Subject: RE: Request for further information BR/55/20/PL

Existing East Elevation

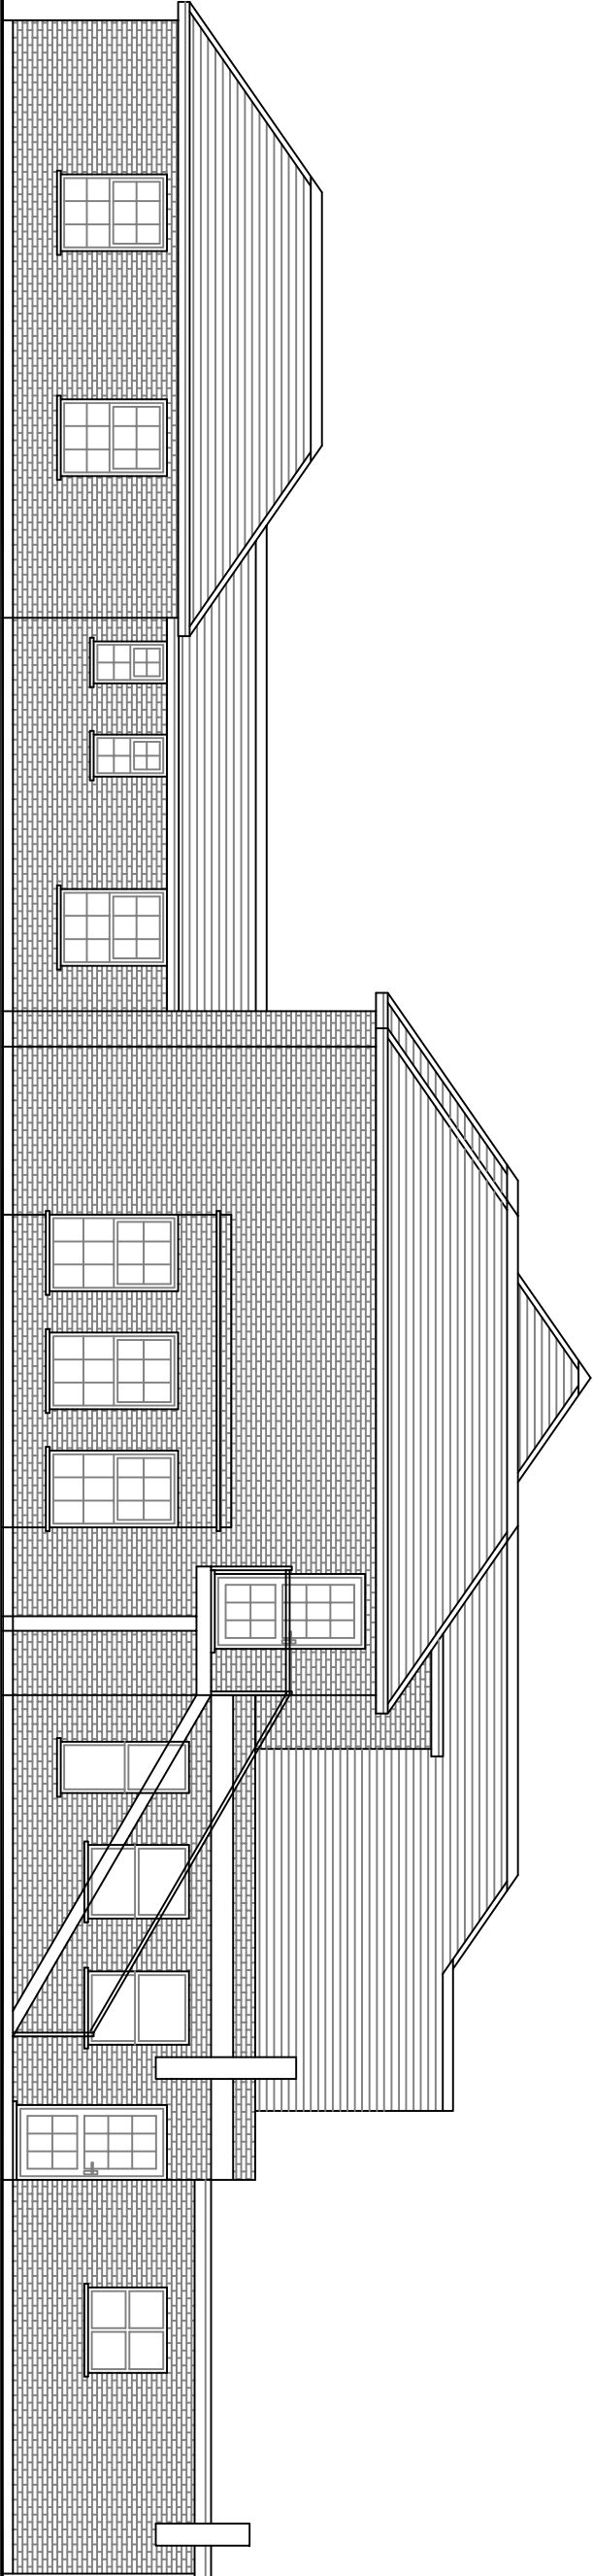
- The existing ground floor plan and north elevation do not accord. Please show the staircase on the floor plan.
- The existing ground floor plan and east elevation do not accord. Please show the staircase on the floor plan.
- The existing first floor plan and north elevation do not accord as there is a window missing.
- The proposed ground floor plan and east elevation do not accord. Please show the staircase on the floor plan.
- The proposed first floor plan and north elevation do not accord as there is a window missing.
- We still await the fee.
